## WEST SUSSEX COUNTY COUNCIL CONSULTATION

| <b>LOCATION:</b>                                | Land west of Brook Lane and South of A259<br>Angmering BN16 3JL                                                                                                                                                                                                                                                                                                                                                                                                                                                 |
| <b>SUBJECT:</b>                                 | A/26/21/RES<br><br>Approval of reserved matters following outline consent A/44/17/OUT for appearance, landscaping, layout & scale for the demolition of existing buildings on site & erection of a mixed use development comprising of 90 No. residential dwellings & a care home & ancillary facilities including railway crossing together with associated access, car parking & landscaping. This application also lies within the parishes of Rustington & Littlehampton.<br><br>More information received. |
| <b>RELEVANT PUBLIC RIGHTS OF WAY NUMBER(S):</b> | Foot

2. Site Analysis
Site Access / Connectivity

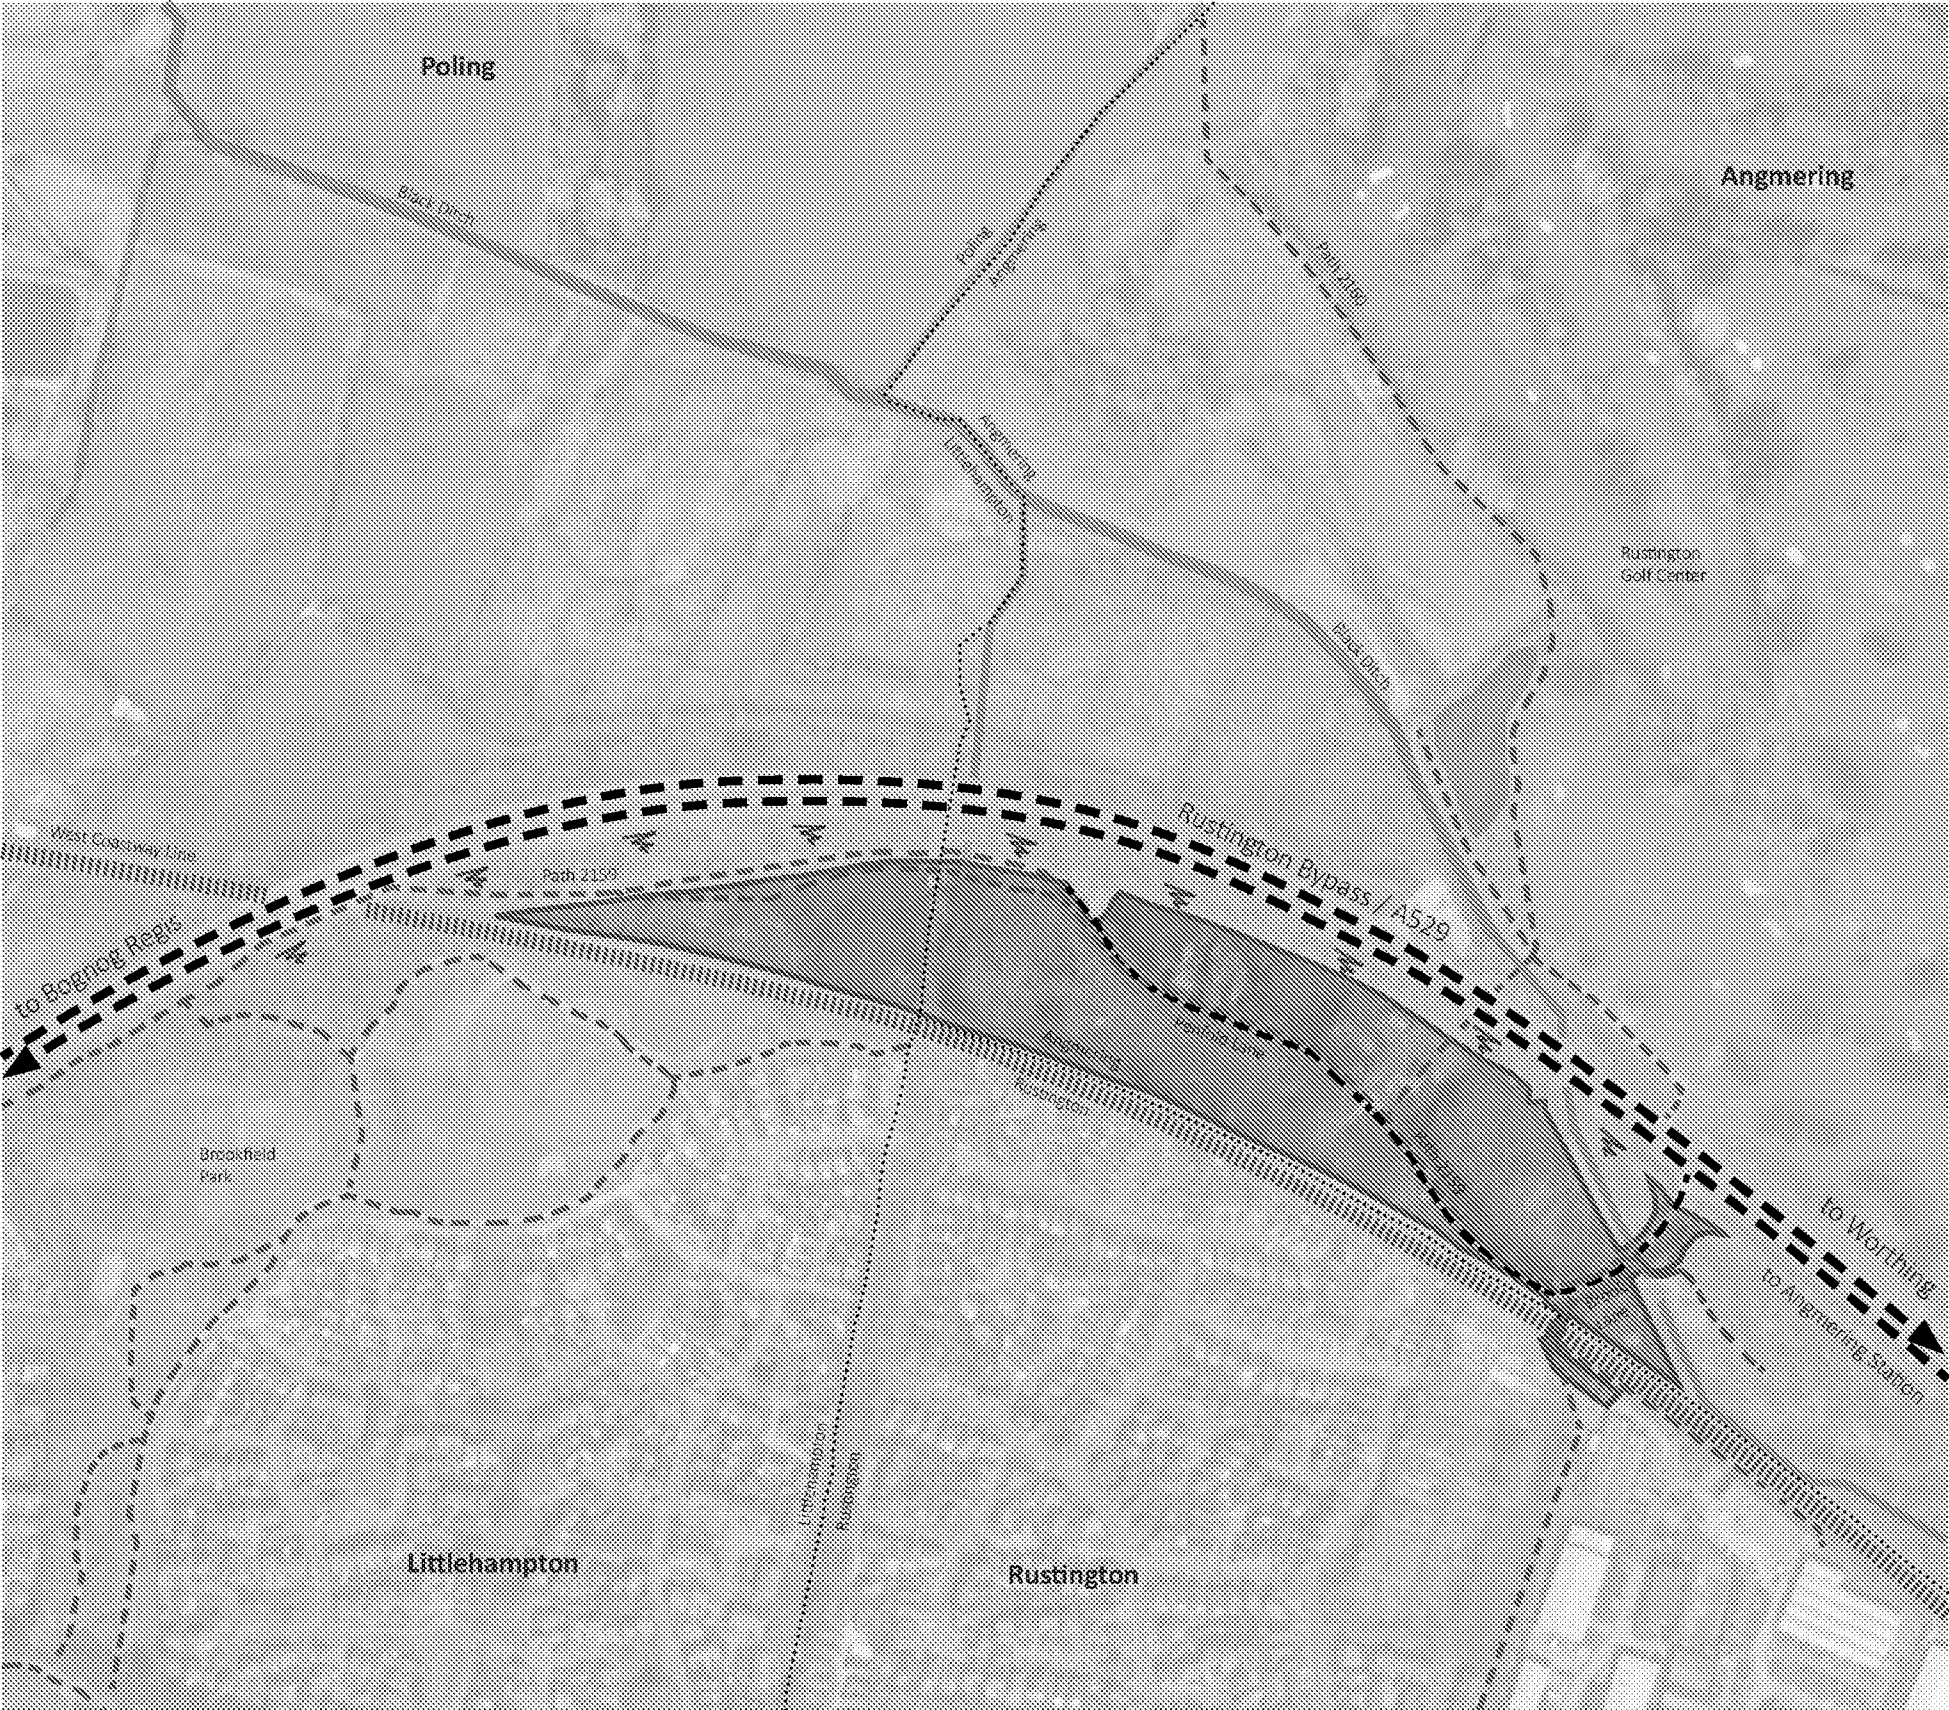
We note that the line of PRow Footpath 2160 on the developer's plans does not follow the legal line as shown on the Definitive map.

Any change to the legal line is subject to an application by the developer to Arun District Council to divert it via a Public Path Order (PPO) under Section 257 of the Town & Country Planning Act 1990 before works start. There are two stages, the 'making' and the 'confirmation'. Application for a PPO can begin prior to the granting of planning permission however the PPO will only progress to the 'making' stage. The 'confirmation' of the diversion can only proceed once planning permission has been granted.
